**Environmental Impact Statement, Sirius Development, 2-60 Cumberland Street,
The Rocks – SSD 10384**

Place Management NSW have reviewed the Environmental Impact Statement (EIS) for the restoration and refurbishment of the Sirius Site (State Significant Development Application – SSD 10384) and ask that you consider our comments and recommendation provided in the attached document.

PMNSW Response to Environmental Impact Statement – SSD 10384

DWG. TITLE  
**Landscape Plan - BASEMENT B2-B1**

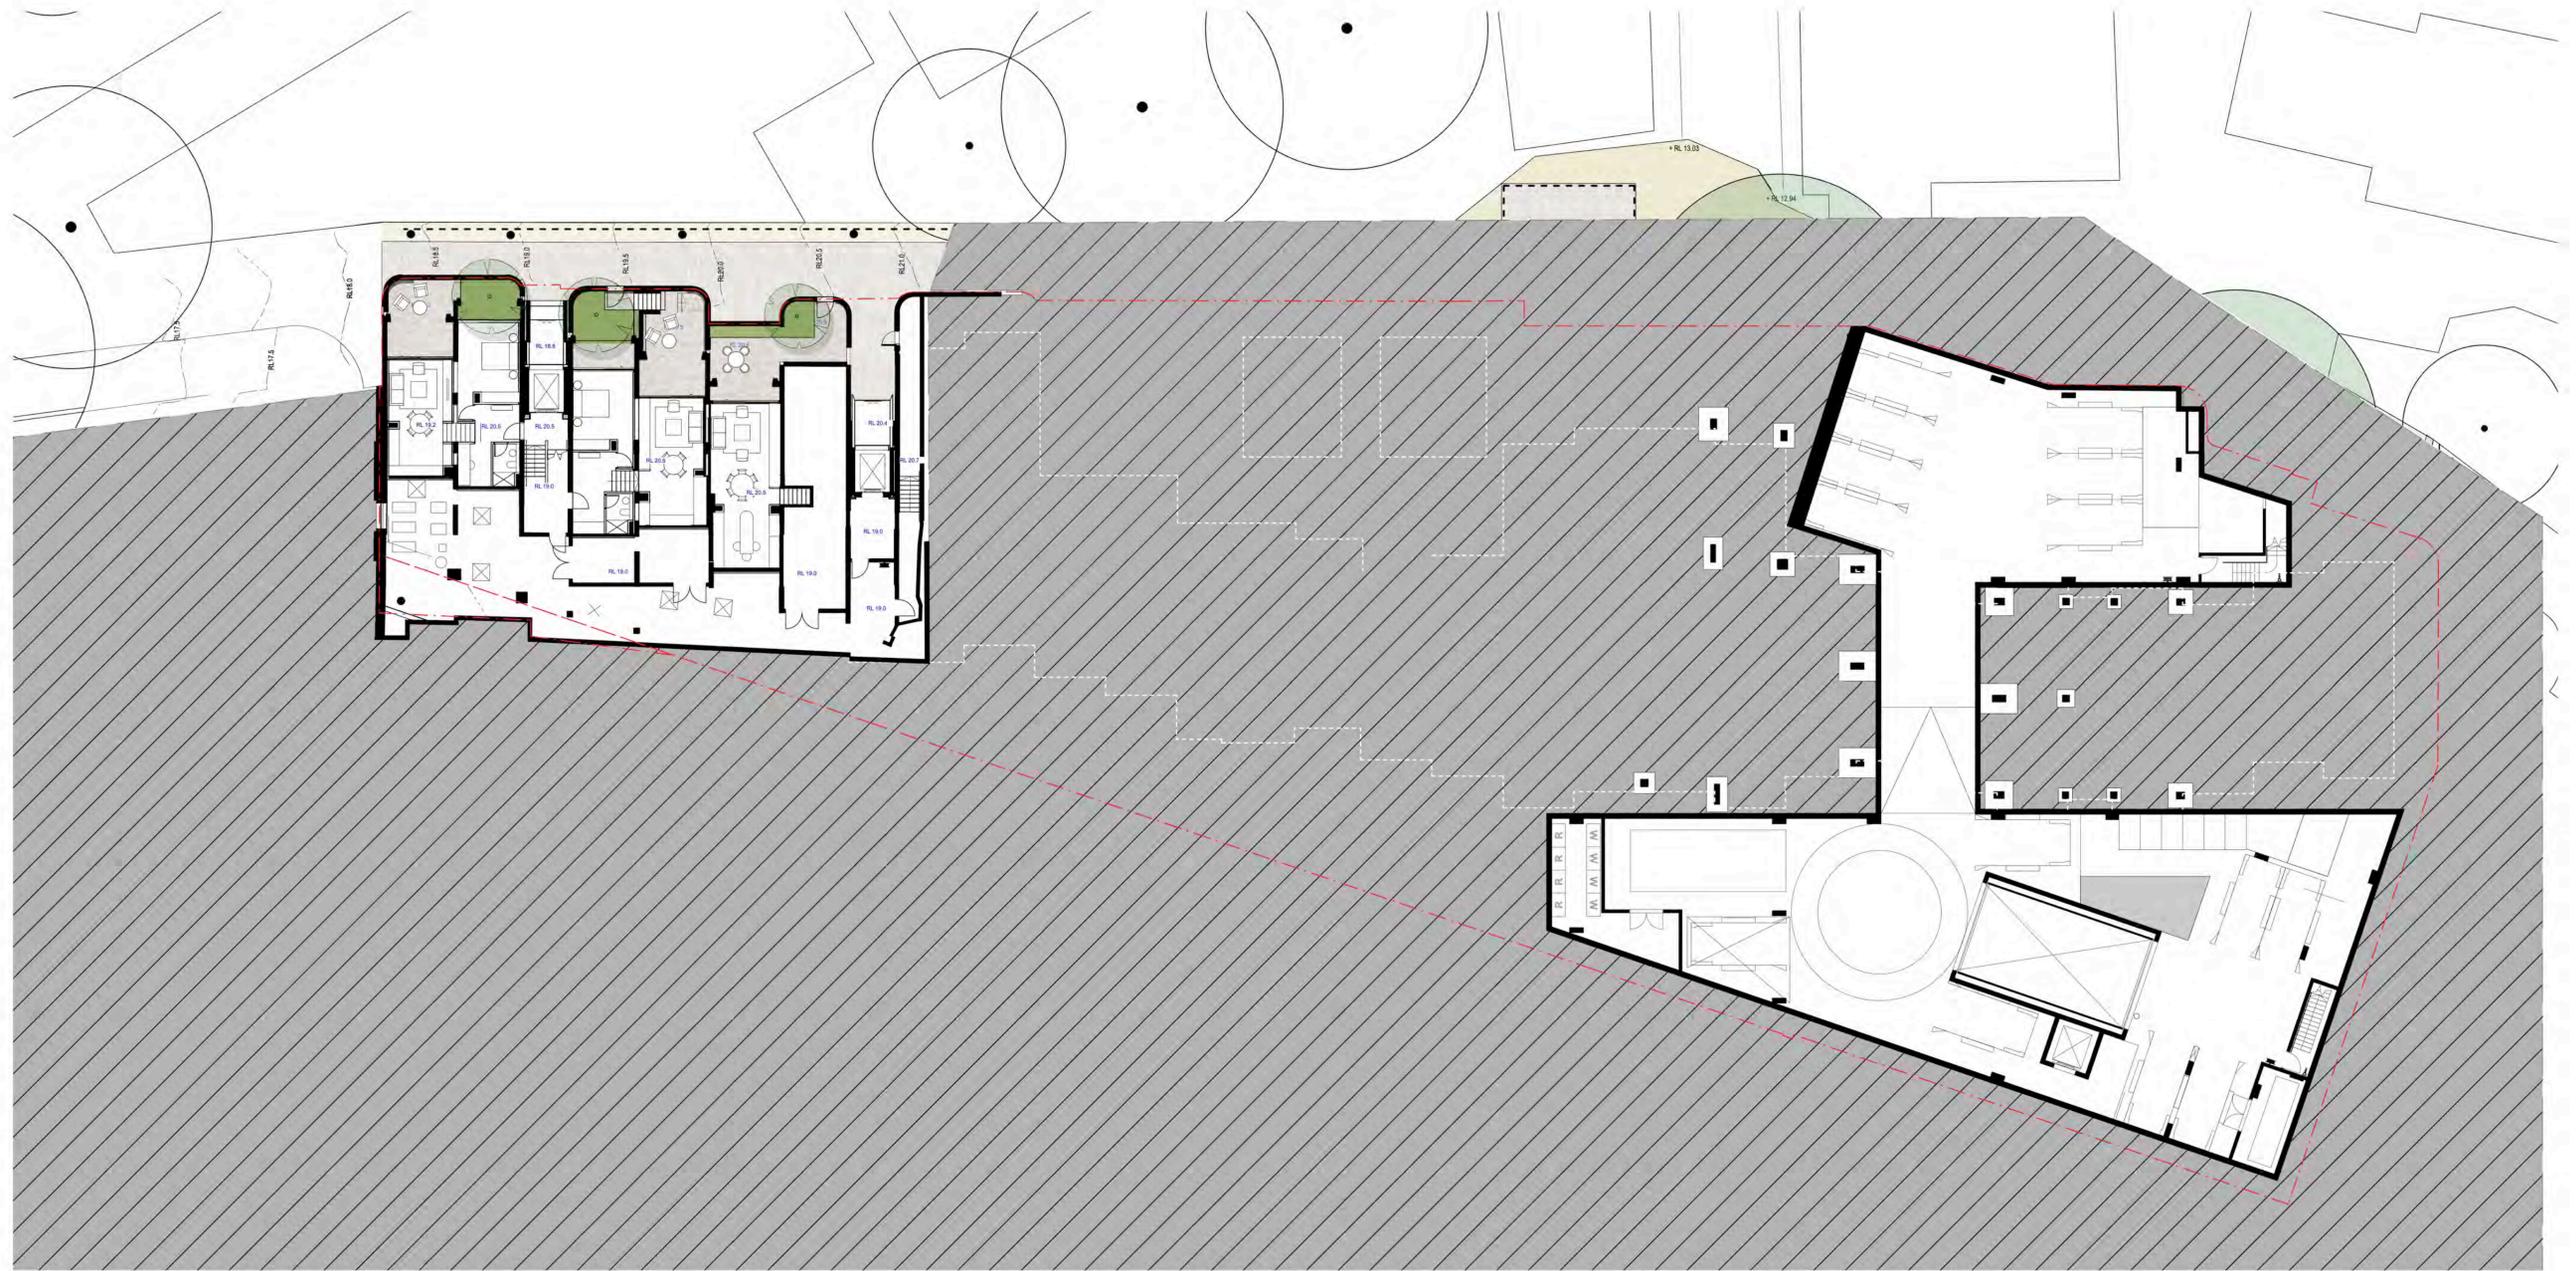
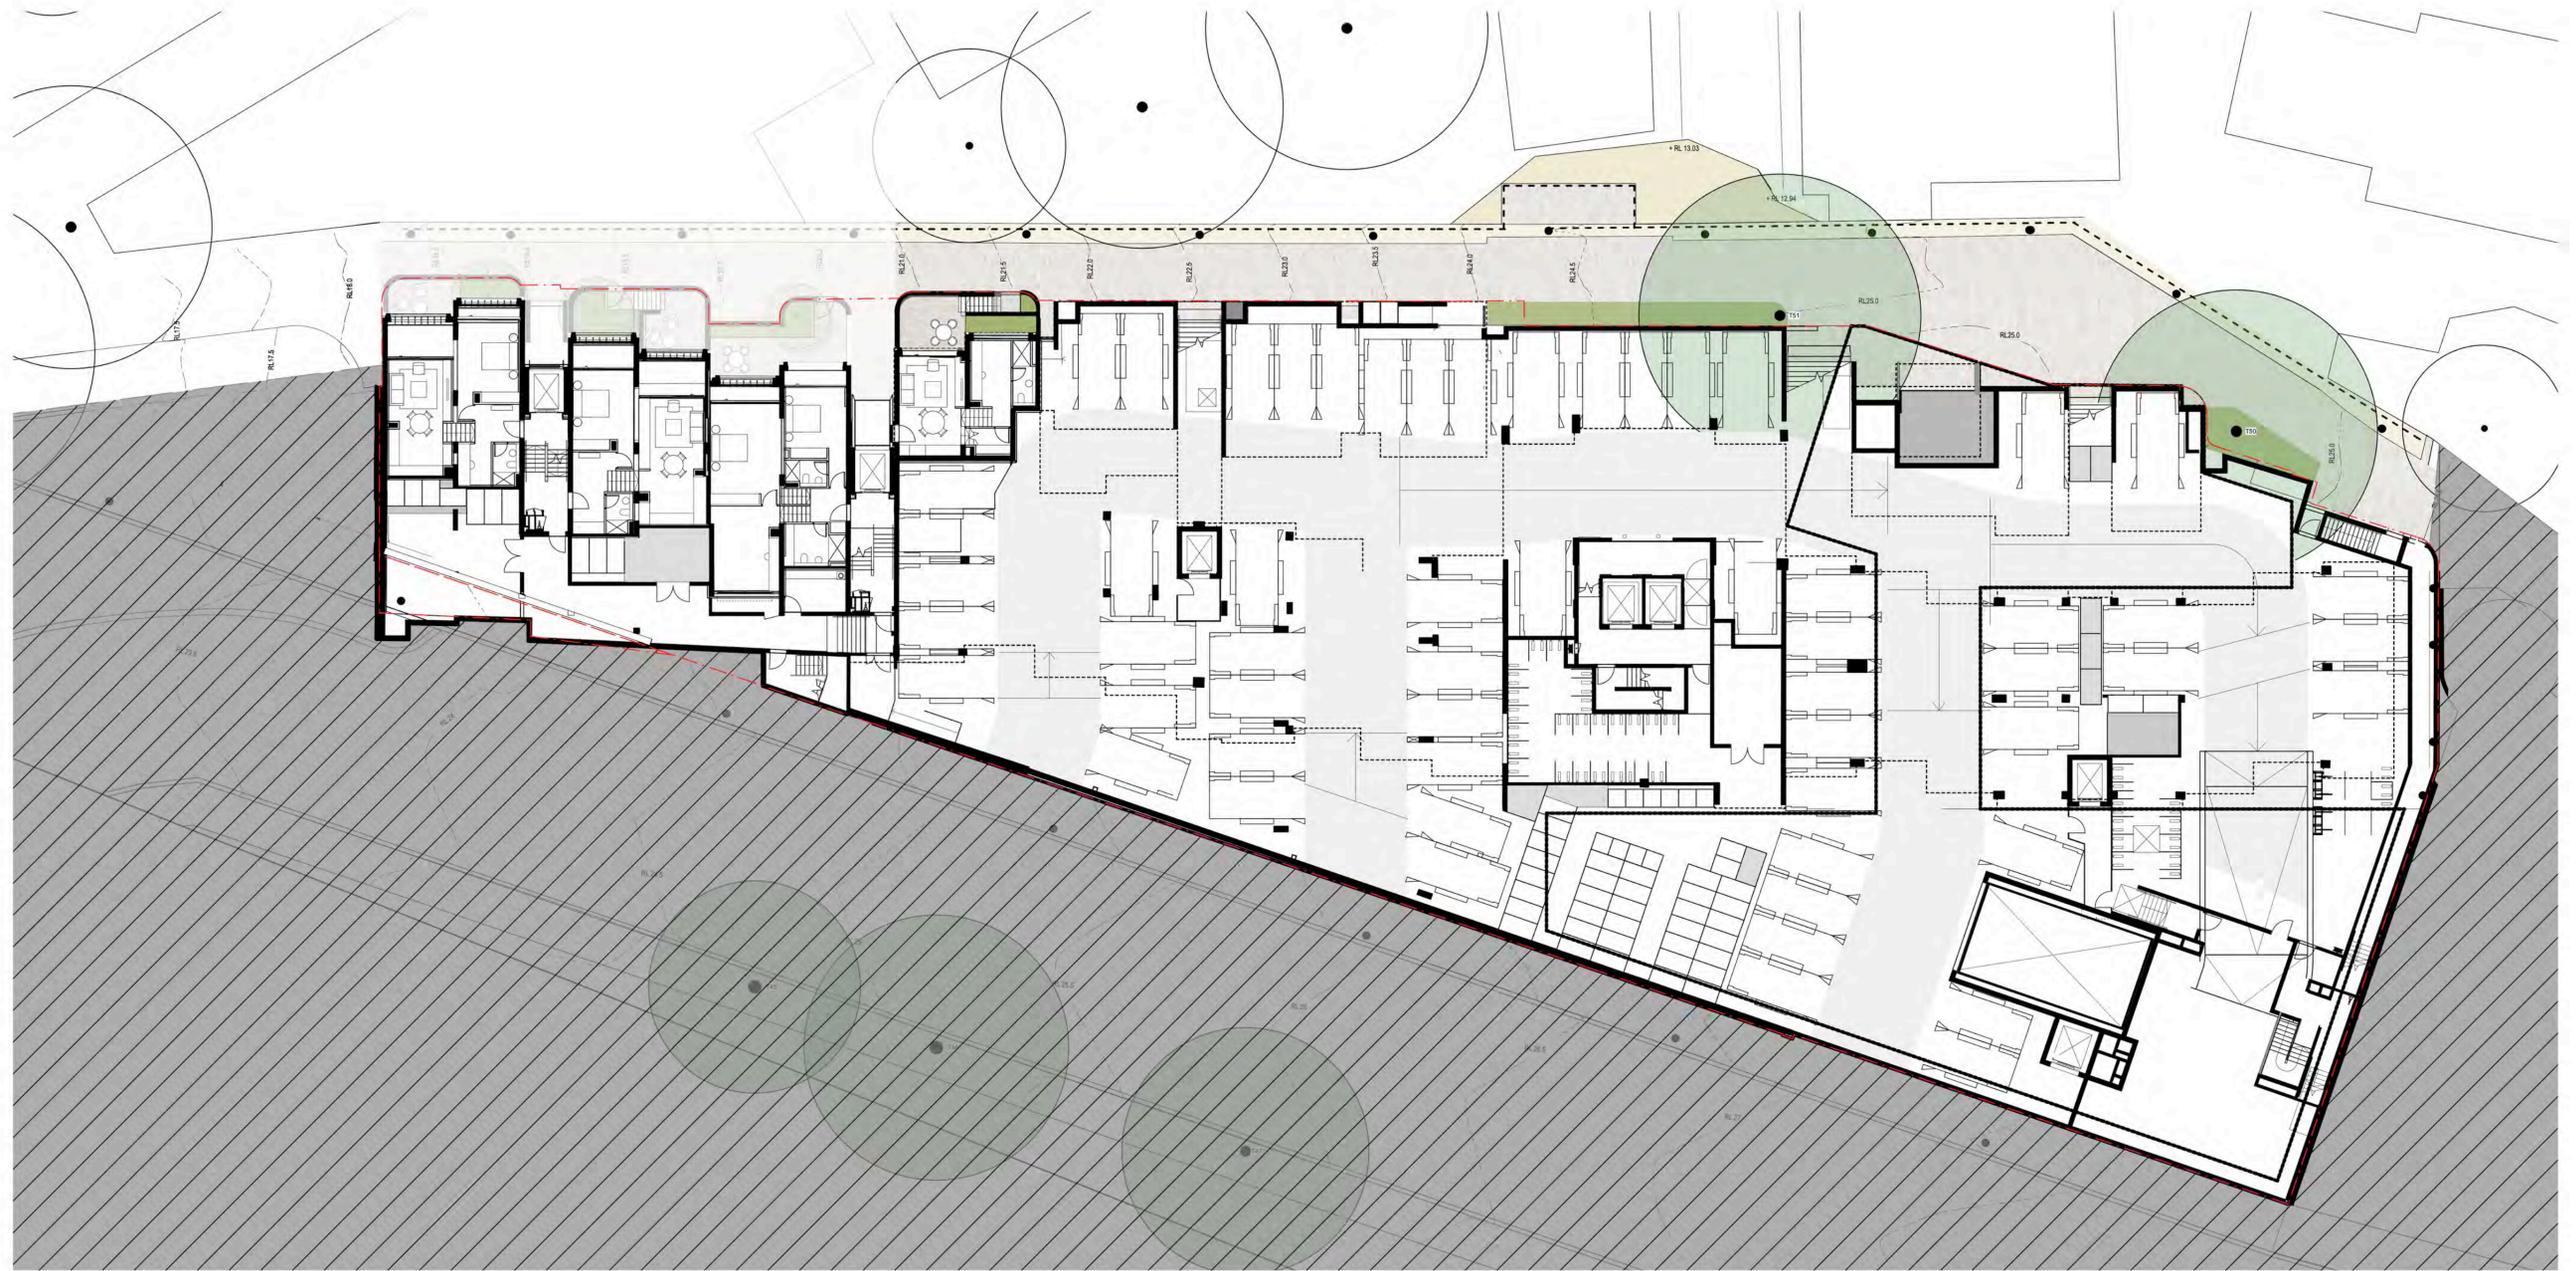
<p>The moderate impacts as noted in the VIA are acceptable and do not require any mitigation.</p> <p>The perspectives indicate green walls on the facade facing Gloucester walk - on Soho Style commercial / residential as well as the through link. These are not referenced in the landscaping report or drawings.</p> <p>This green is beneficial to soften the building and improve amenity to Gloucester walk and should be retained</p>	
Historical Archaeological Assessment (Appendix P)	<p>Section 4 does not take into account significant archaeological findings on the sites directly adjacent to the south (Immigration House and Glenmore Hotel), and does not examine the historic photographic evidence indicating the siting and nature of the early 19th century buildings that formerly fronted Gloucester Street (Walk).</p> <ul style="list-style-type: none"> • 2.2.1 does not clearly state that the site <u>is</u> subject to the archaeological requirements of s139 of the Heritage Act since Sirius is not identified as an item on the State Heritage Register (s60) • There is a difference of approximately 4-5 metres between the Cumberland and Gloucester frontages, and it has therefore been assumed by the authors that the bedrock was quarried in relatively modern times. Evidence along this ridge indicates terracing dating from as early as 1820, dividing properties facing Cumberland Street from those fronting Gloucester Street. • The extent of site excavation in the late 1970s for the current building is unclear. The current basement carpark floor is on a similar level with Gloucester Walk. Pre-1900 photographs and other evidence indicates on-grade access from the former houses that stood on this site onto Gloucester Walk (formerly Gloucester 	<ul style="list-style-type: none"> • It is therefore recommended that further archaeological assessment, including historical research, is undertaken for the site, with particular reference to the areas of proposed disturbance. • Assessment should include exploratory test excavation at the earliest convenience to assist in identifying potential archaeological deposits and determining appropriate methodologies for treatment of the resource. All archaeological investigation should be undertaken in accordance with the NSW Heritage Act (1977), Division 9.
